## Planning Conservation & Design Consultation

**Consultation on Application Number:** 2018/92842

**Address:** Former Combs Hostel, Hall Lane, Thornhill, Dewsbury, WF12 0PL

**Proposal:** Reserved matters application for erection of 30 dwellings pursuant to outline permission 2014/92815 for demolition of existing hostel buildings (C1) and erection of residential development

Site Plan 1: 100

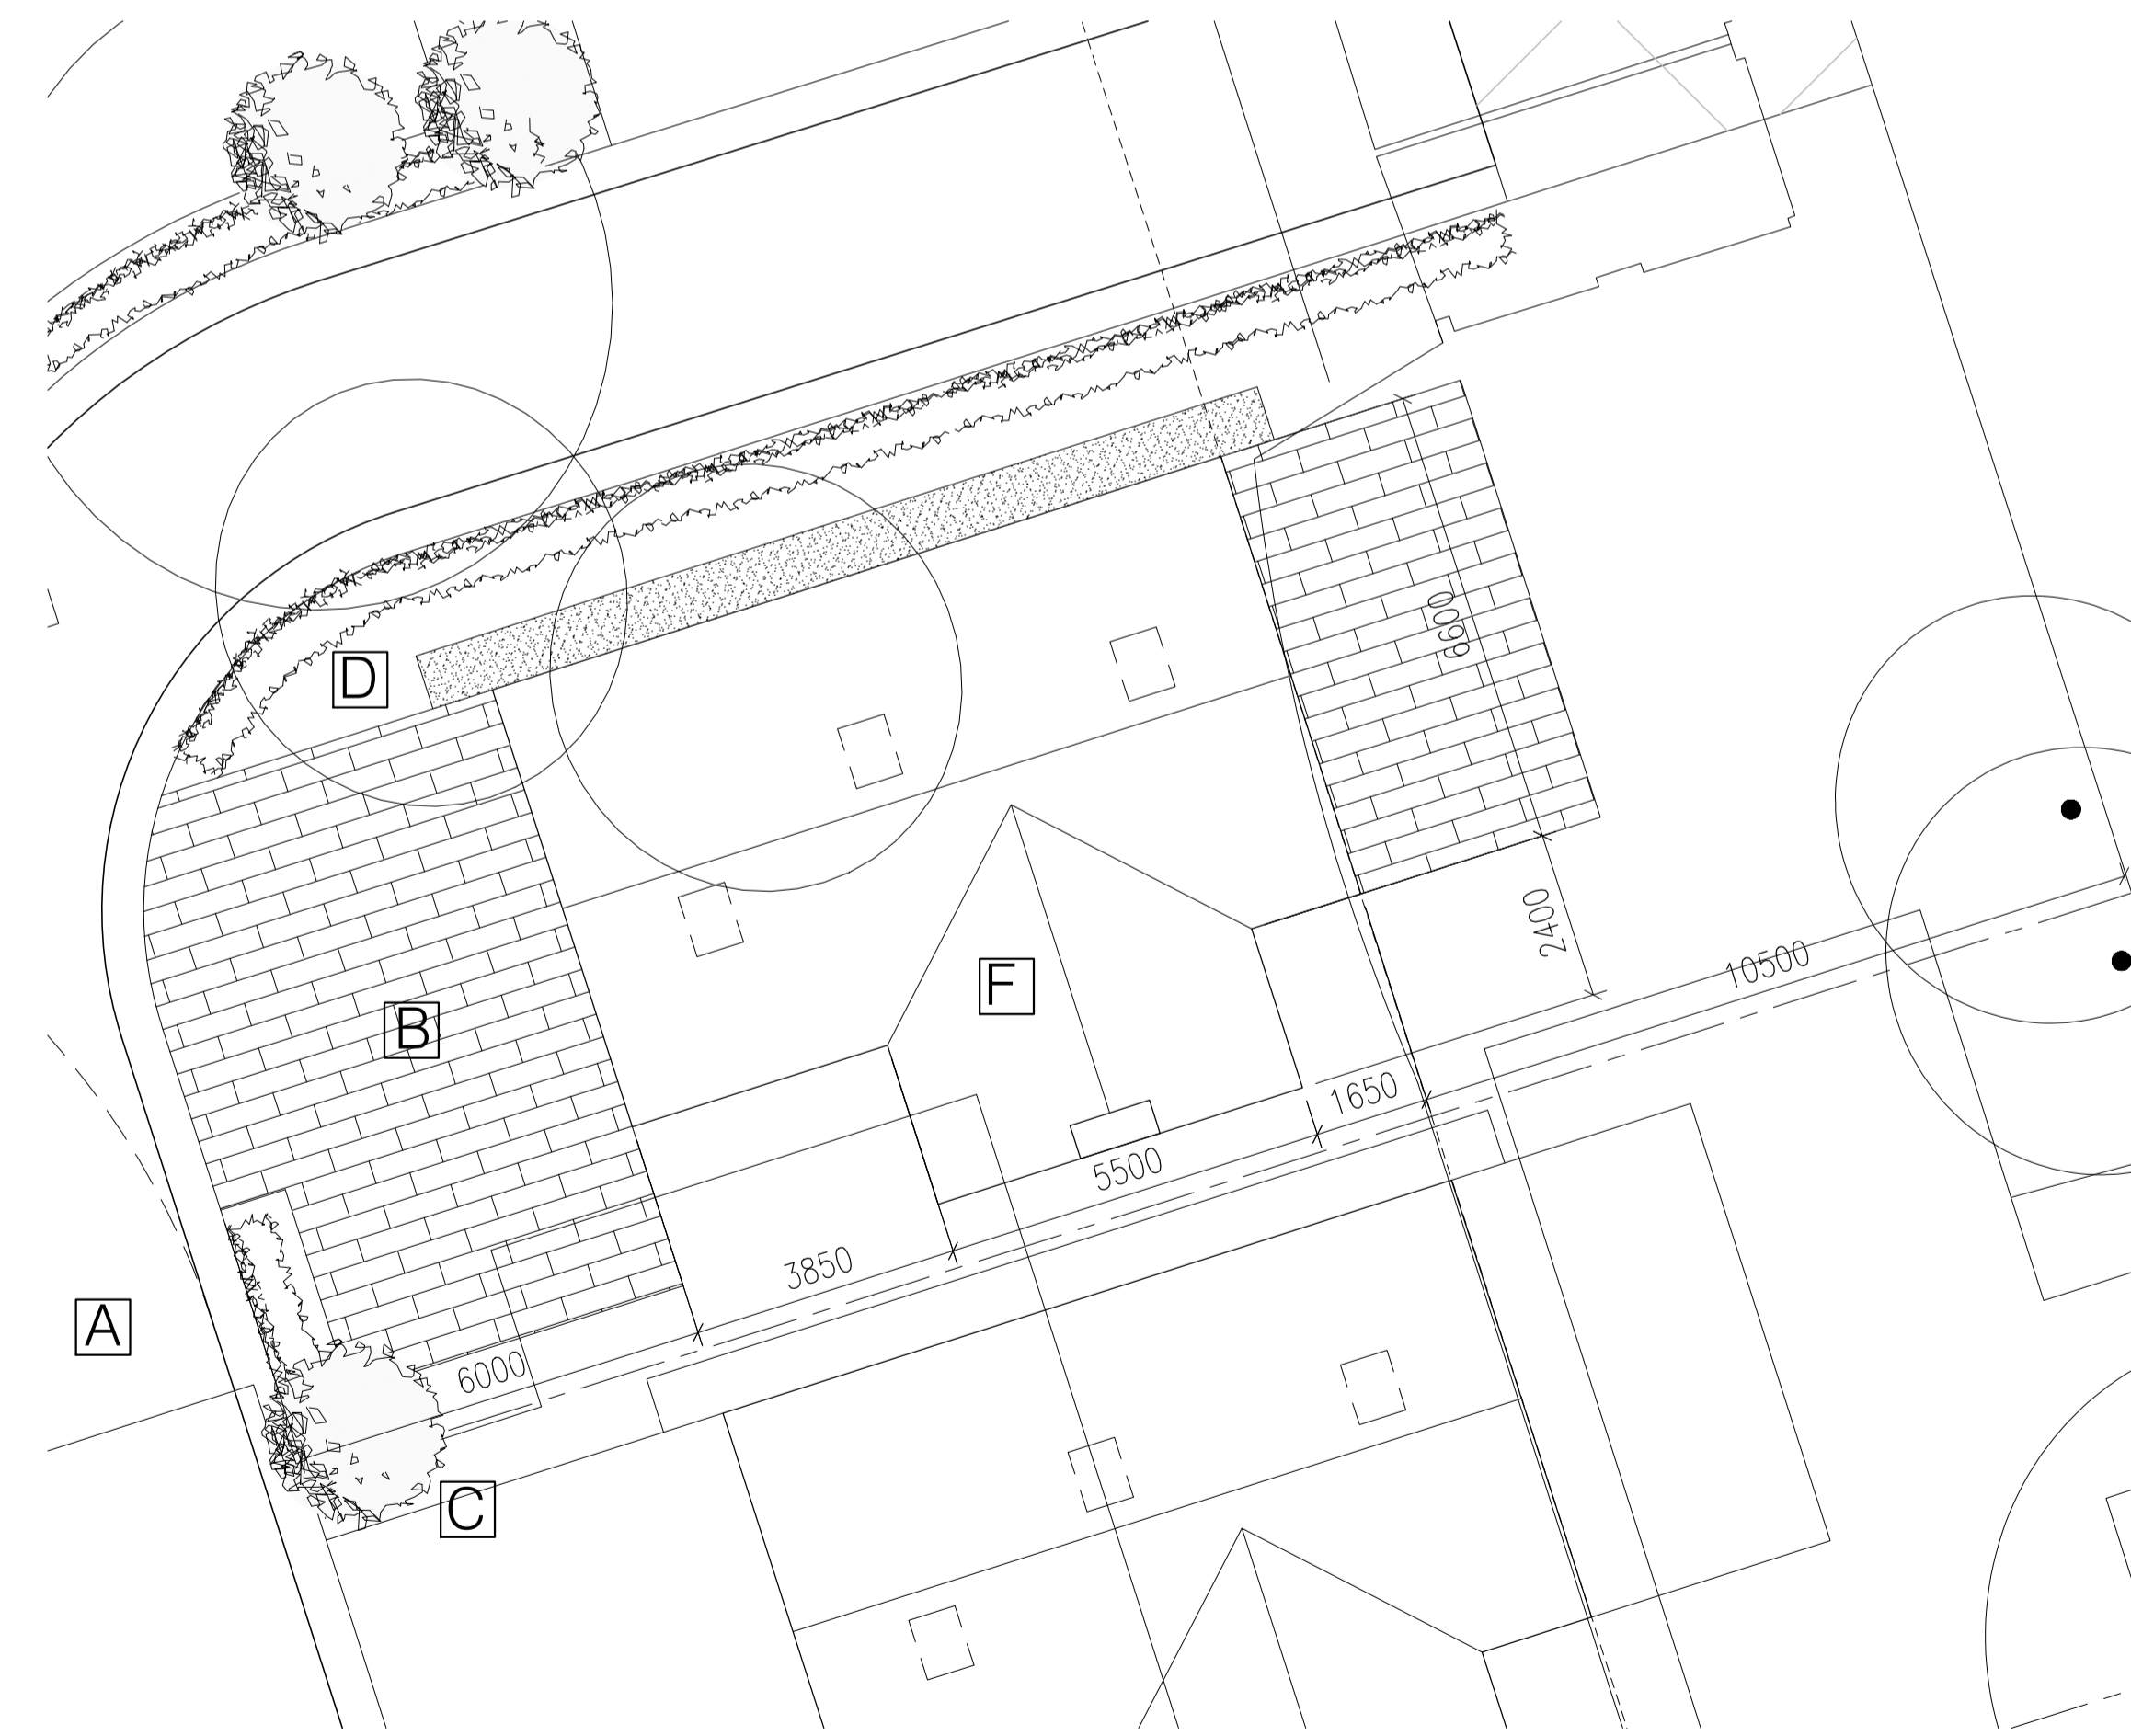
The proposed development is for 30 detached dwellings on the site of the former Combs Hostel on the north side of Hall Lane. The layout of the proposed development is quite dense and overly regular, with slightly smaller plots book-ending a broadly symmetrical block plan. The weakest aspect of the proposal is plots 21-30 which back on to Hall Lane, this is not characteristic of the older areas of Thornhill. Details of the materials to be used for the elevations of the houses is not clear, areas with brickwork texture are clearly labelled as brick, but plain areas are unlabelled. It should be clarified if these are also to be brick or rendered. Existing trees and hedgerows are to be retained and some further trees and hedges are to be planted, which is welcomed. As proposed the development would cause some harm to the significance of designated heritage assets.

The proposed development would respond better to the historic character of Thornhill if more variety in the layout of the streets and plots and the density of the development was introduced. This could be achieved by a greater density of development, perhaps rows of townhouses at the west end of the site and decreasing density through the site towards the east, with houses set in more spacious grounds at the eastern end. The layout should be revised so that no properties back onto Hall Lane.

Revised proposals should be sought that better reveal the significance of the conservation area and take the opportunities available for improving the character and quality of an area and the way it functions.
